Our Ref: M/104/17/HH
Your Ref:

Town & Country Planning Act 1990 (as amended)
Town & country Planning (Development Management Procedure) (England) Order 2015
Application for Planning Permission for Works or Extension to a Dwelling

Development Alterations & enlargement of existing ancillary residential outbuilding including new single storey extension
Location 41 Sea Way Middleton on Sea

BLOCK PLAN 1 : 5 0 0

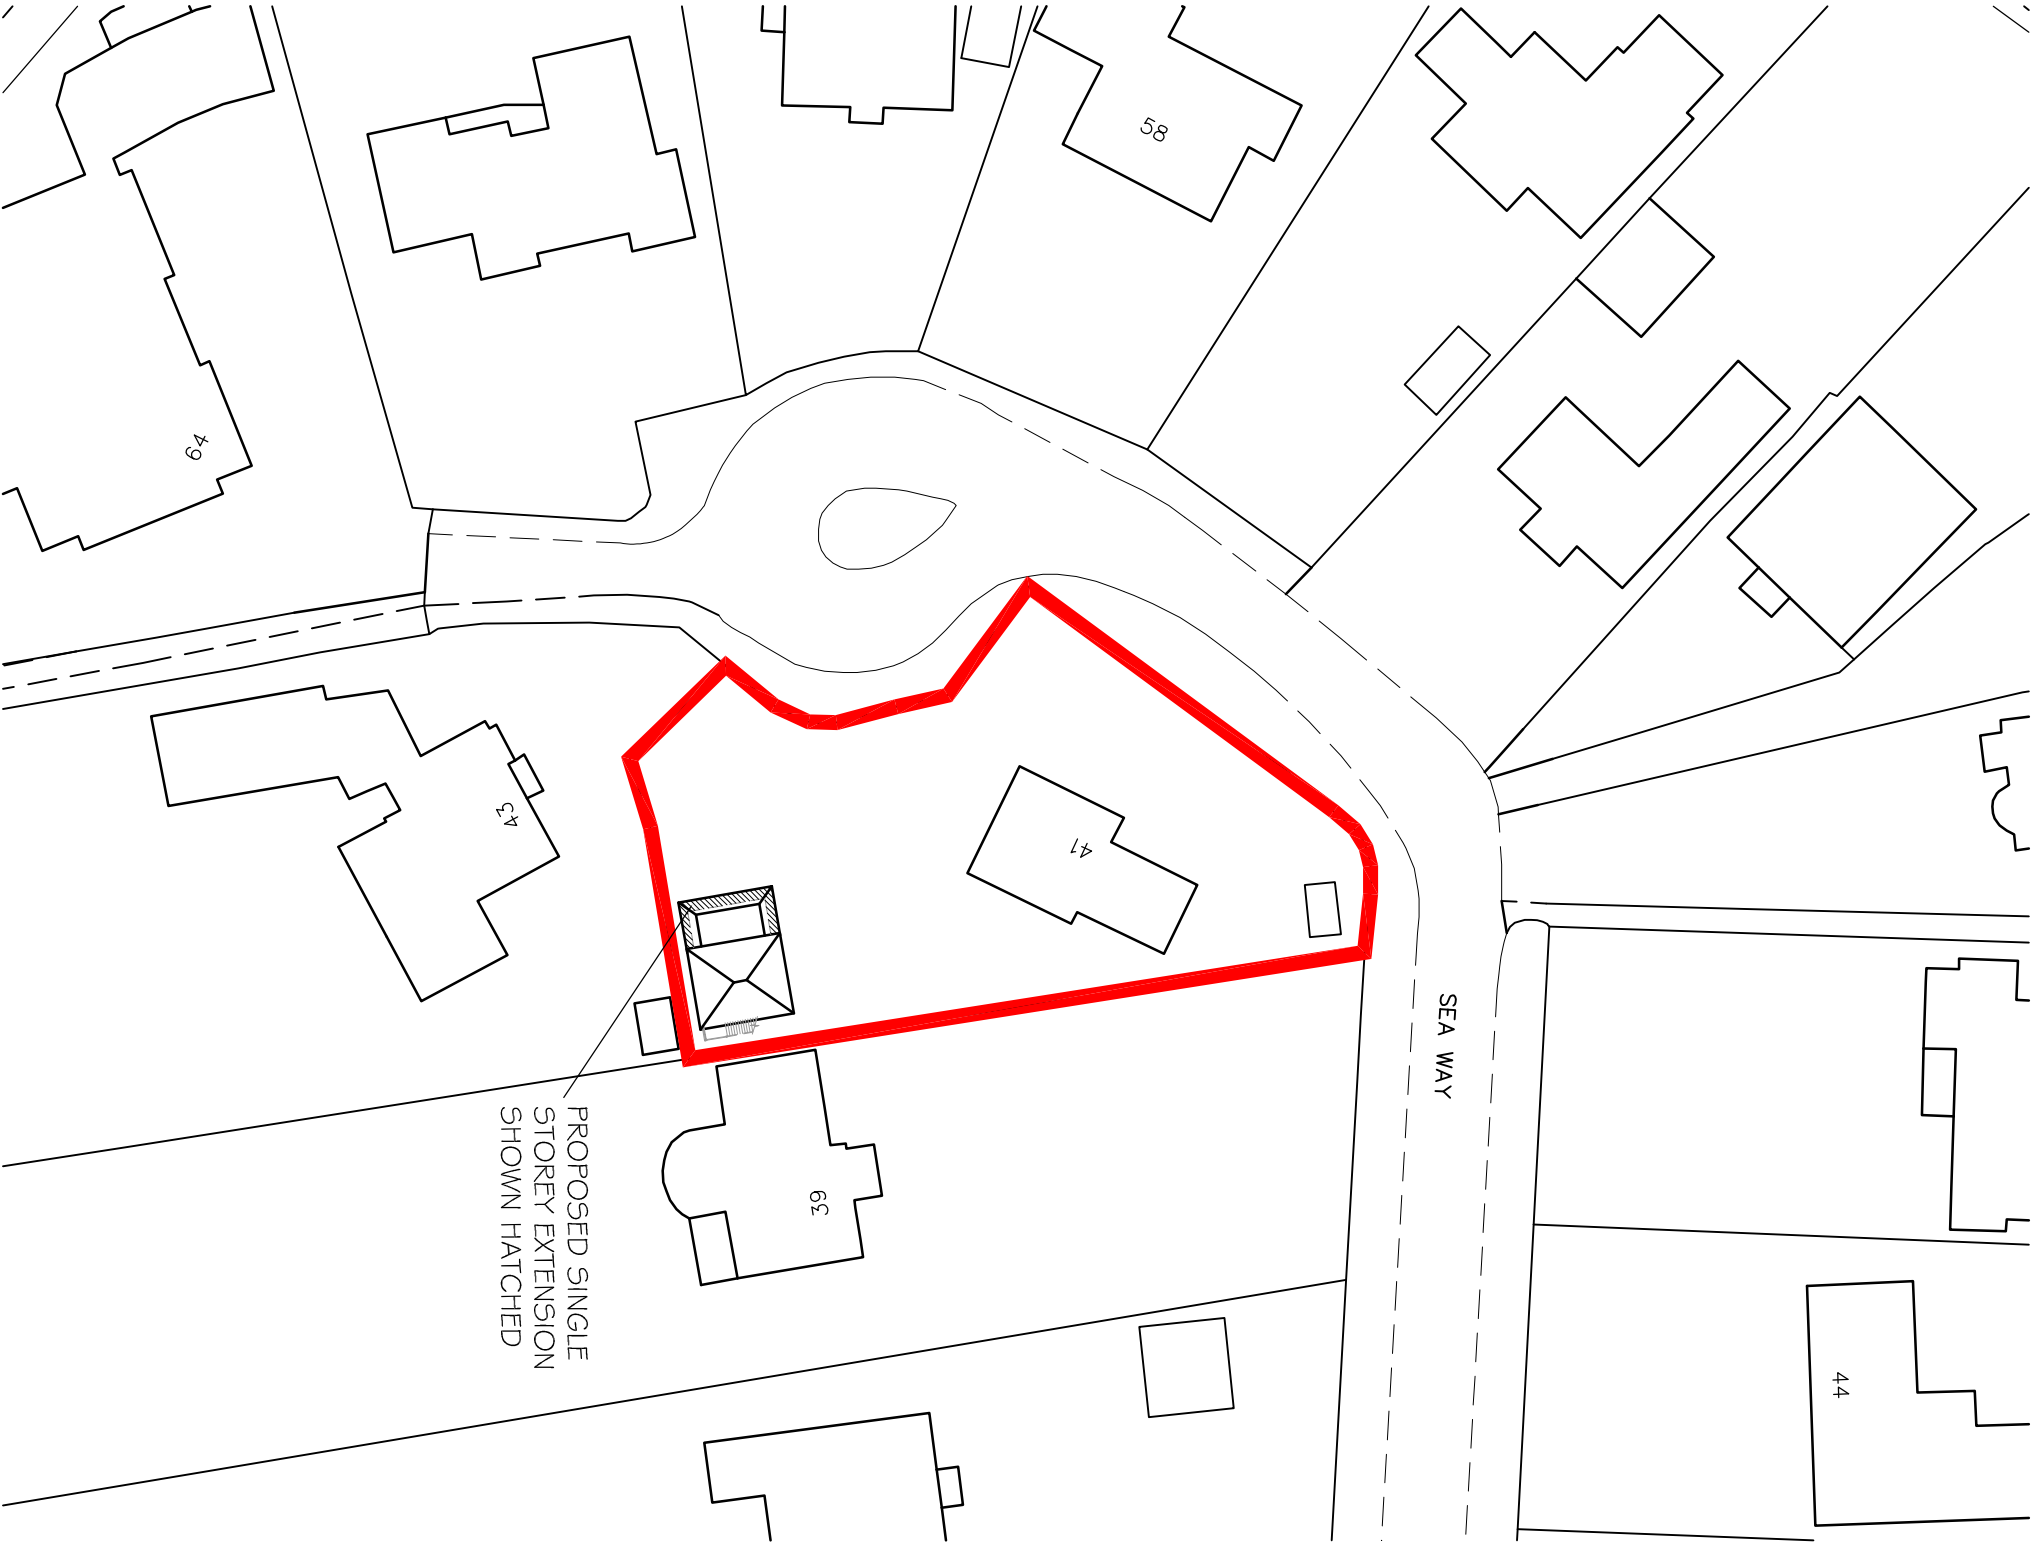
Block Plan - revised

Please submit 1 electronic or 3 paper copies of a revised block/site plan at a scale of 1:500 or 1:200 with the site dimensions clearly indicated from the proposals to the site boundaries. Further details of what must be included on the plan can be found in the National Validation Requirements.
